## Online Comment

**Application** H16-0871-24  
**Location** Land adj Pilgrim's Pride Limited Fulney Lane North Spalding PE12 6EP  
**Proposal** Change of use of agricultural land and development for Solar array of up to 1.64 MWp and associated infrastructure including connection to Pilgrim's Pride Factory adjacent north

**Name** National Grid Electricity Distribution  
**Address** formerly Western Power Distribution

Site Layout

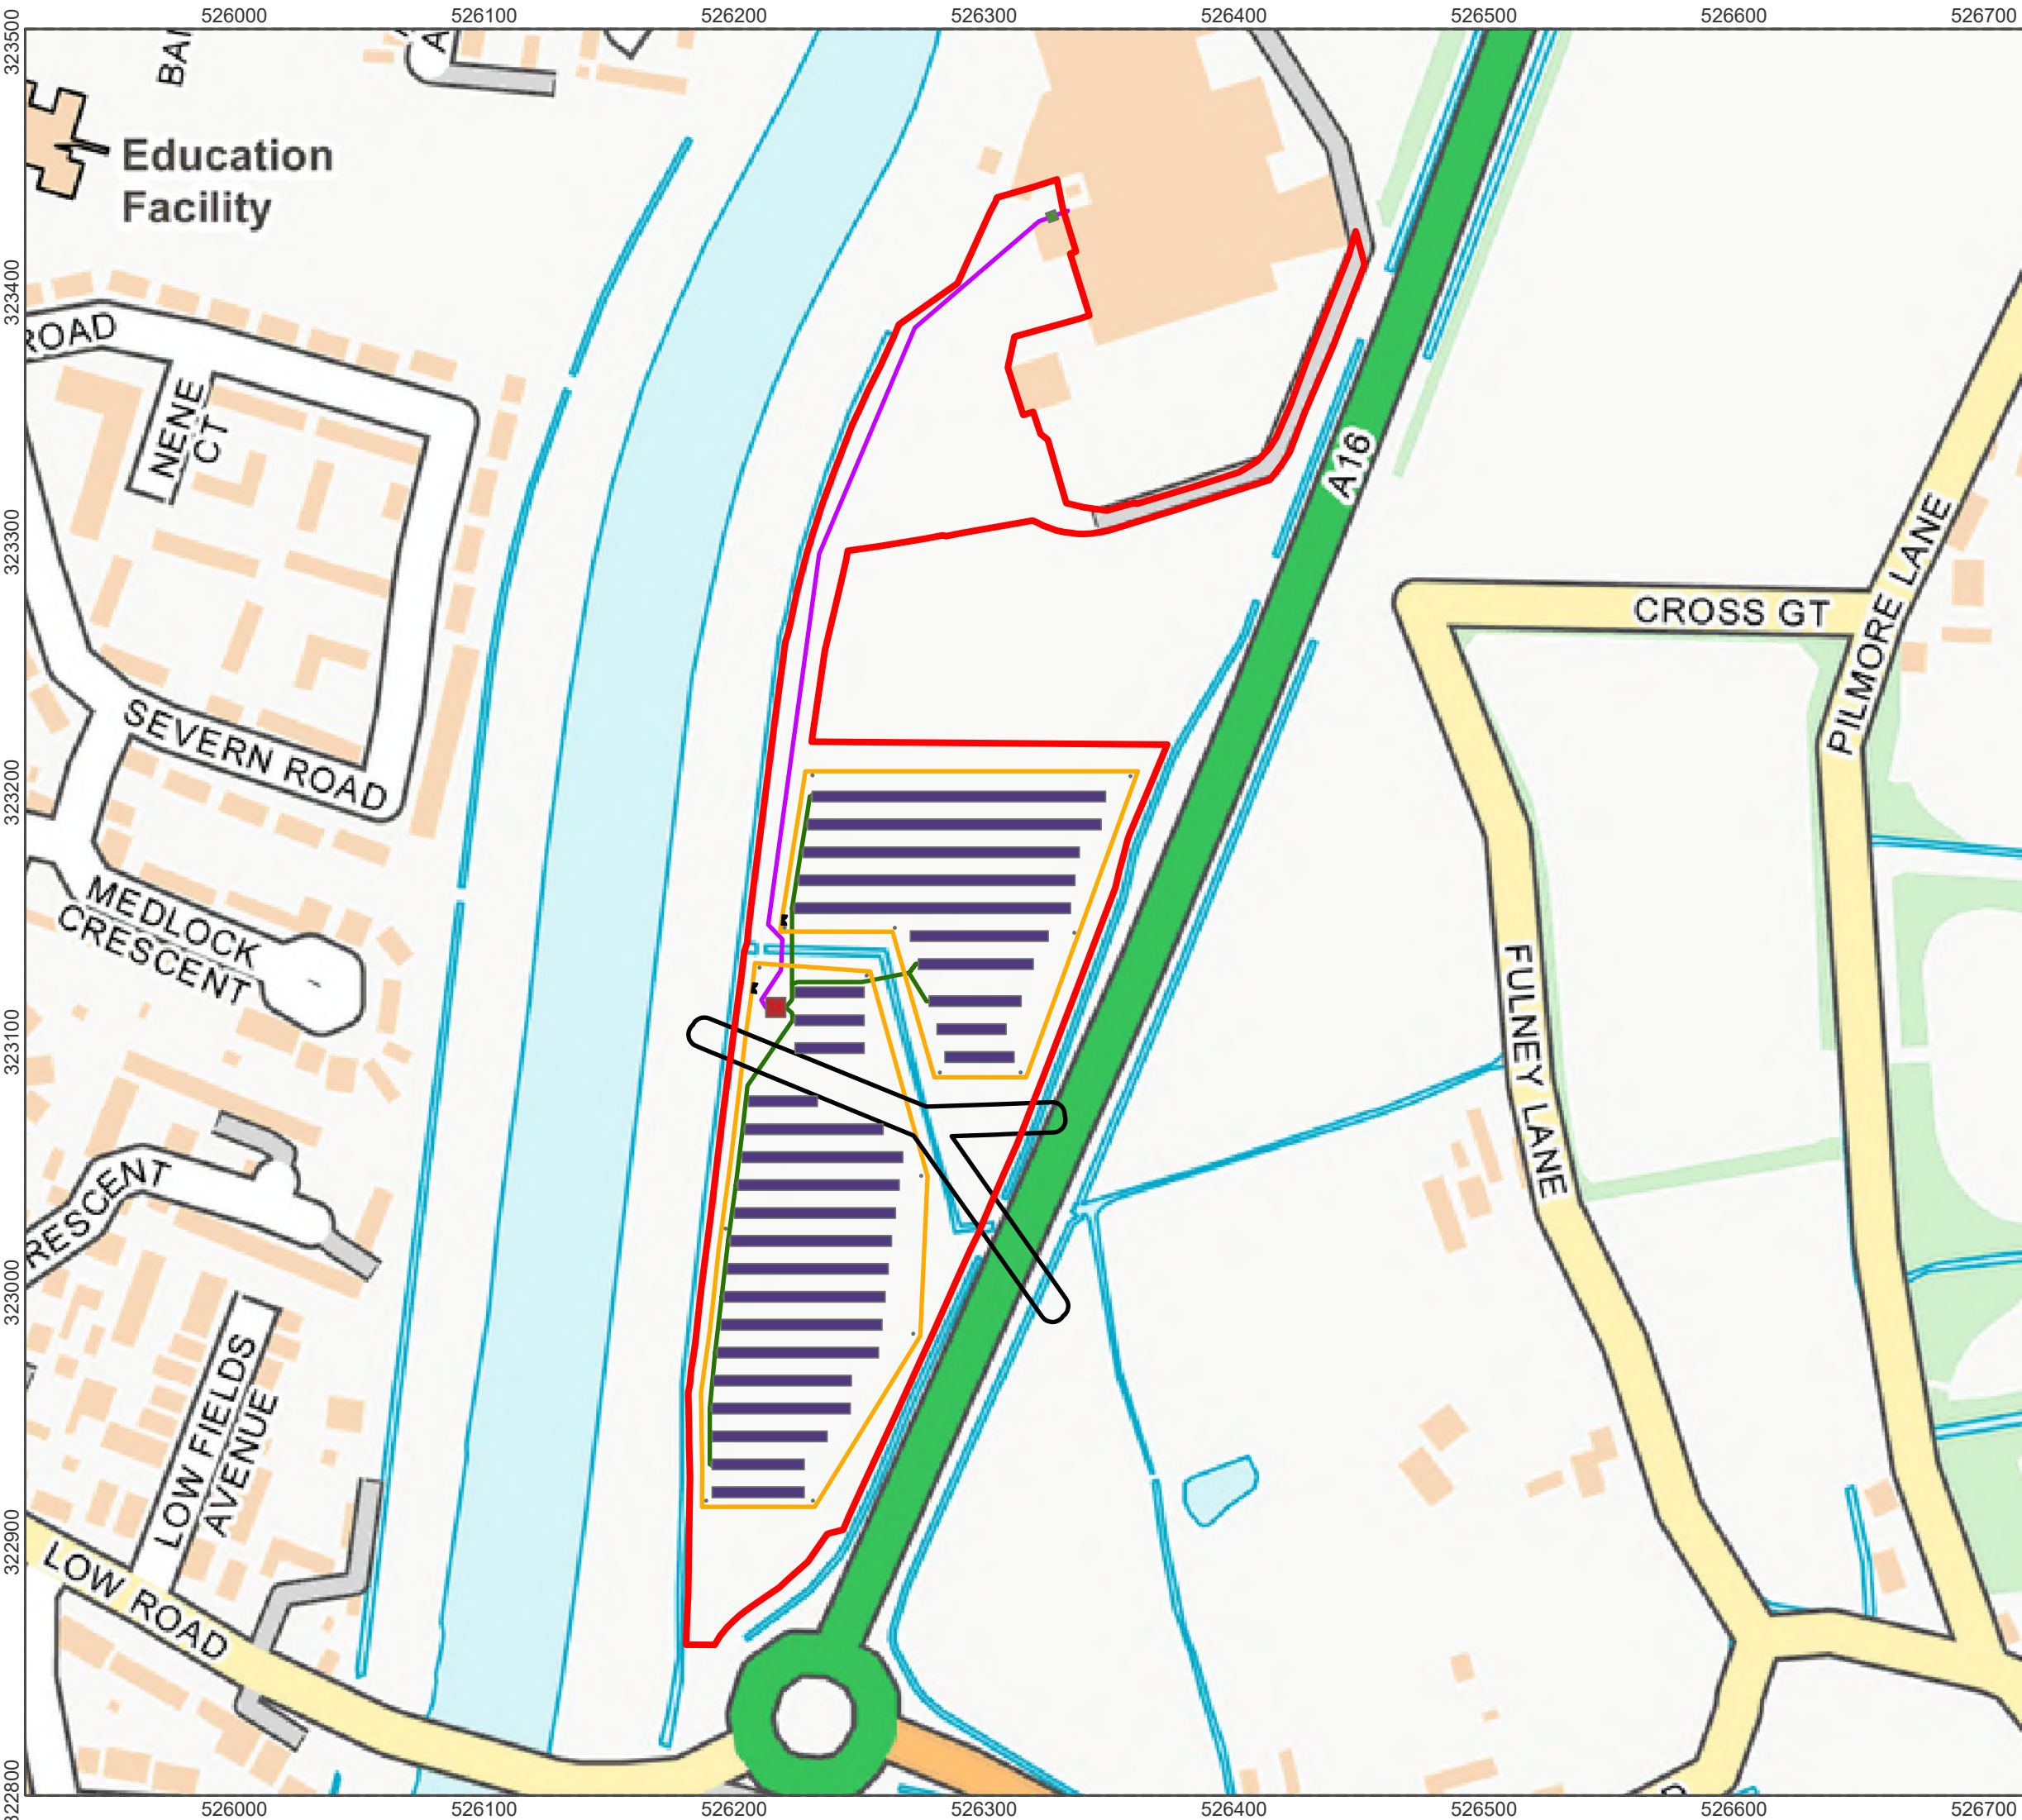
Looking at the site layout plan considerations have been taken into account regarding the 11kv OH line
